**KIRKLEES METROPOLITAN COUNCIL  
INVESTMENT & REGENERATION SERVICE**

**Reference No:** 2017/62/93470/E

**Site Address:** adj, 93, Stocks Bank Road, Mirfield, WF14 9QB

**Description:** Demolition of existing garage erection of detached dwelling with integral garage and associated site works

Side Elevation.
1:50

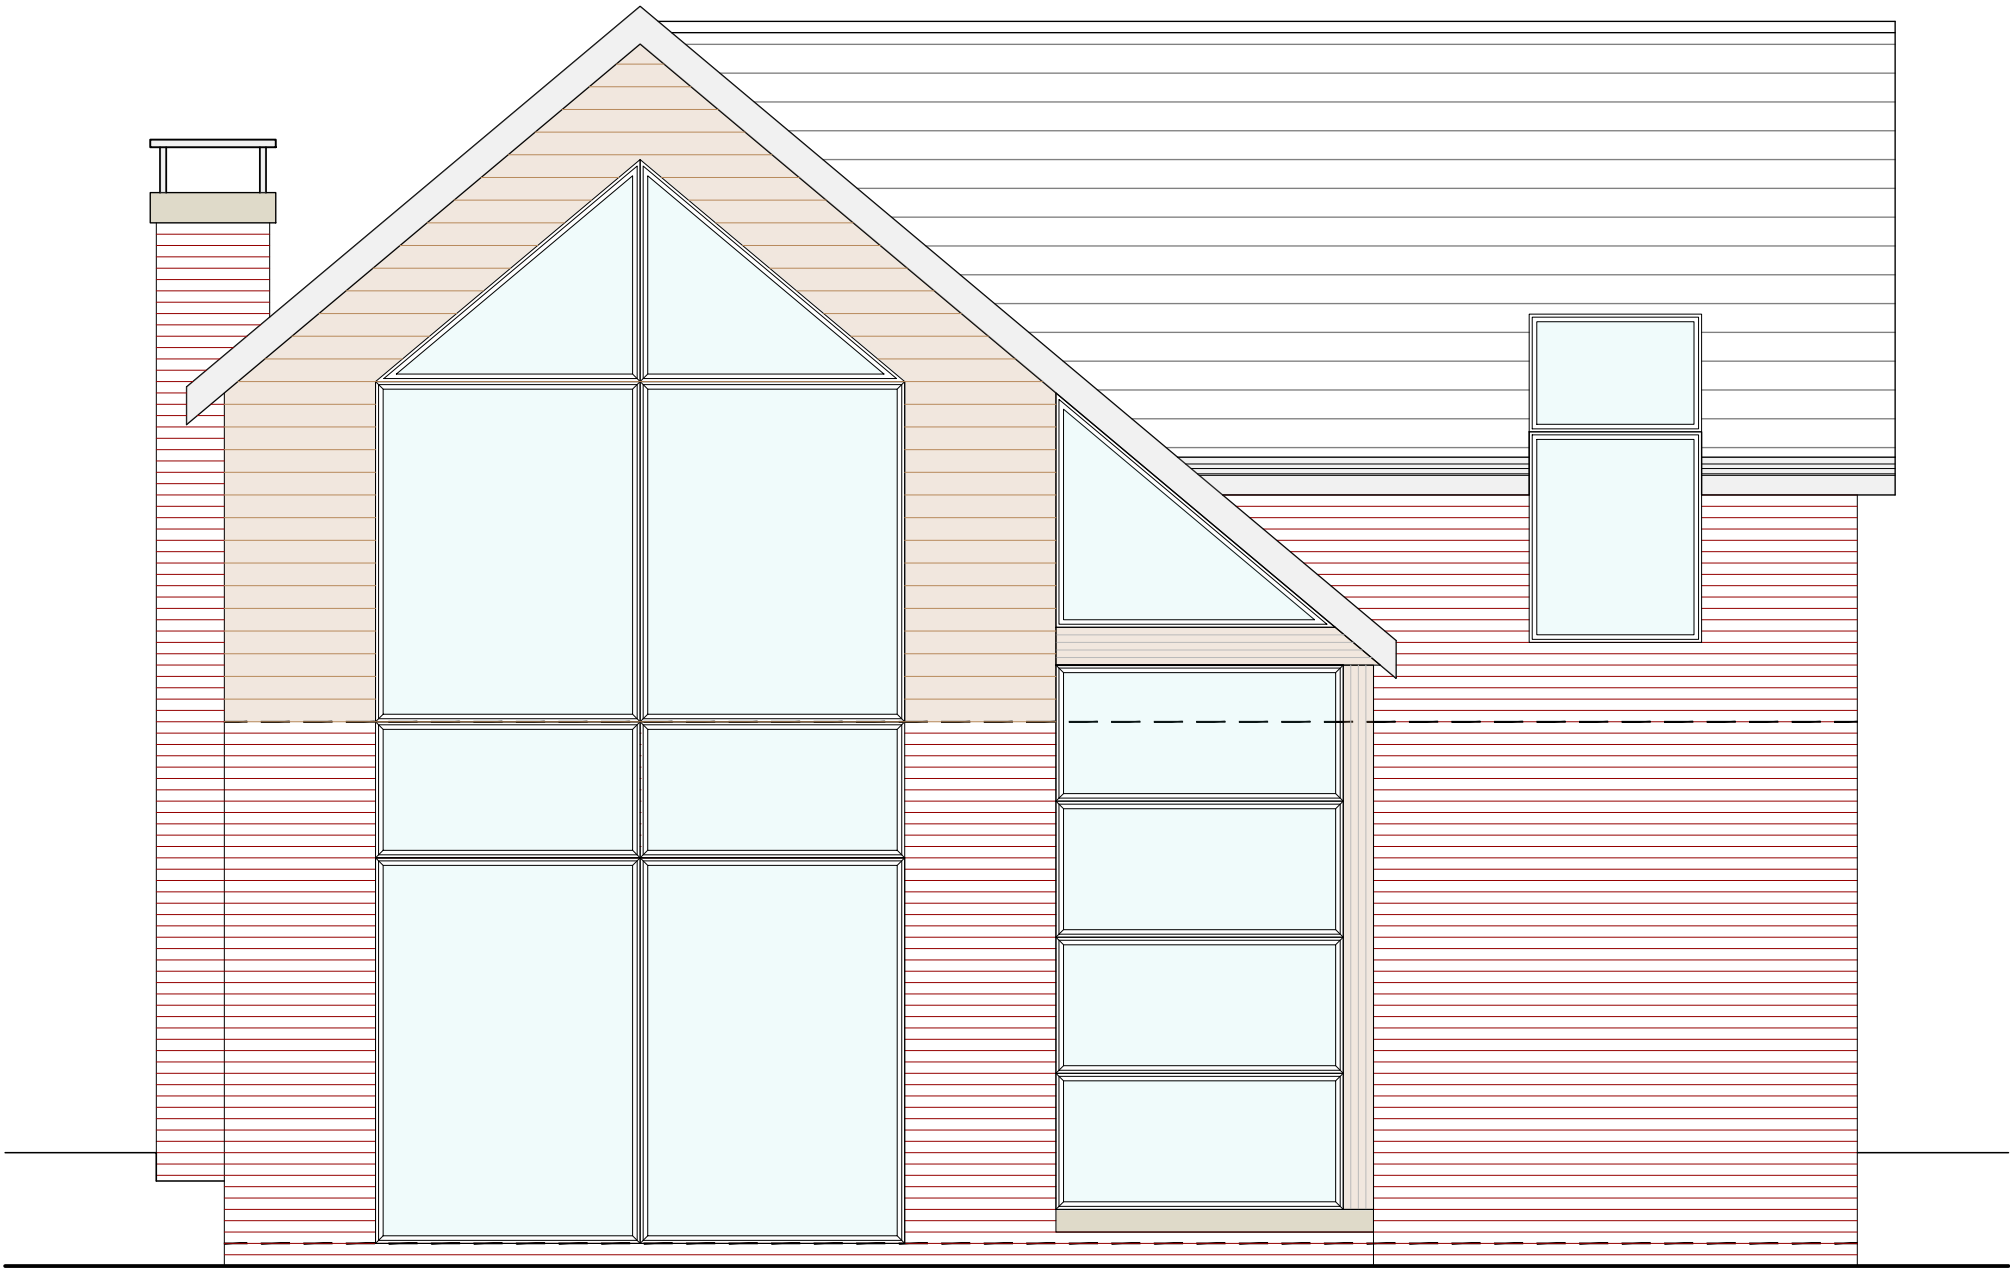
1. The proposed dwelling, by virtue of its scale and proximity to surrounding dwellings, would result in the overdevelopment of the site which would have a detrimental overbearing impact upon the residential amenity of the occupants of the surrounding dwellings, contrary to Policies D2 and BE12 of the Kirklees Unitary Development Plan as well as Policy PLP24 of the Kirklees Publication Draft Local Plan.
